Our Ref: EP/136/11/

Outline application for erection of detached 2 storey dwelling of sustainable carbon efficient design together with car parking space and bin storage area - Resubmission of EP/123/10

Crinnis Seafield Road East Preston

The Planning Committee of this Council met on Tuesday, 7th February, and considered this Application. The Committee agreed to object to this Application on the following grounds:

GROUND / SITE PLAN 1/100

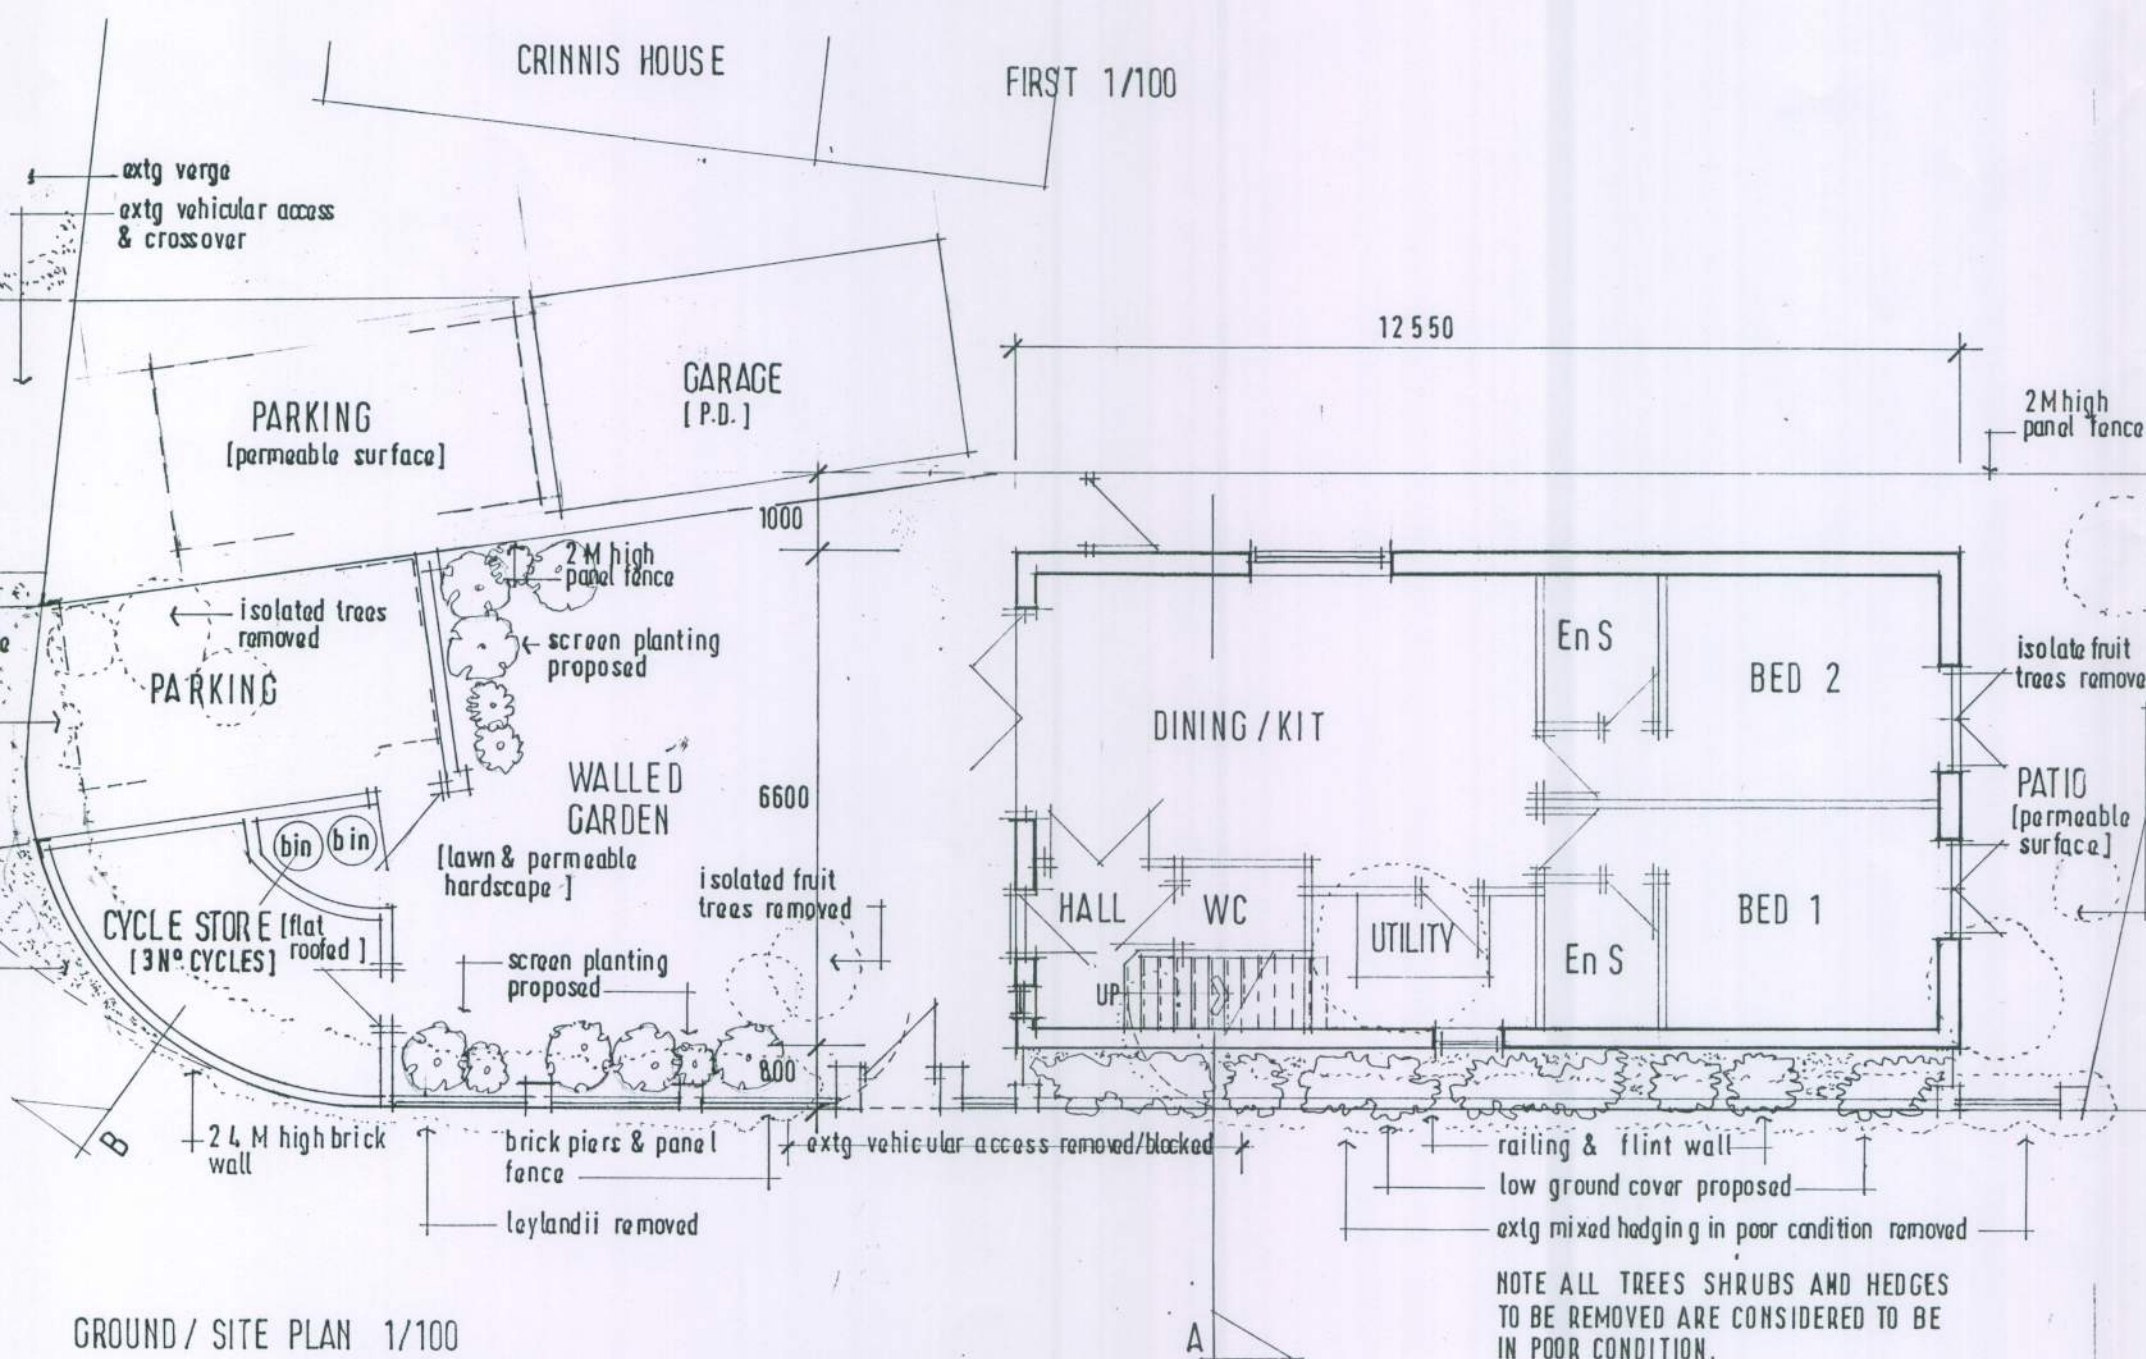
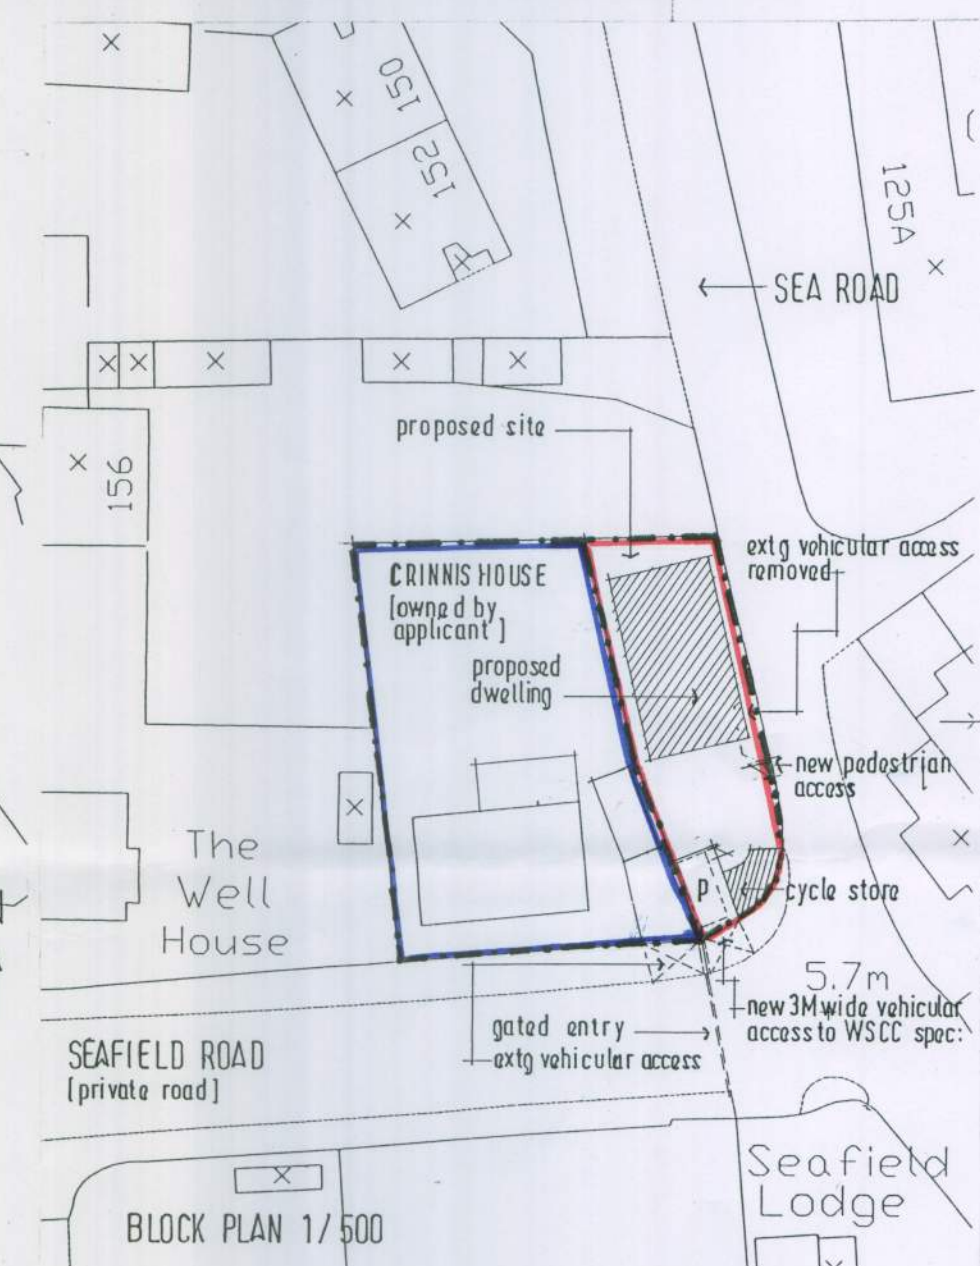
- 3. The proposed development will result in a form of development that would adversely impact upon the spacious character of the area through the introduction of a cramped form of development contrary to the layout of the area. The proposals are therefore contrary to Policy GEN7 of the Arun District Local Plan and policy statements in PPS1 and PPS3.*

- 4. The proposed dwelling on this site would result in an unacceptable relationship with adjoining properties and adversely impact upon the future occupants of the proposed dwelling through a loss of residential amenity contrary to Policy GEN7 of the Arun District Local Plan.*
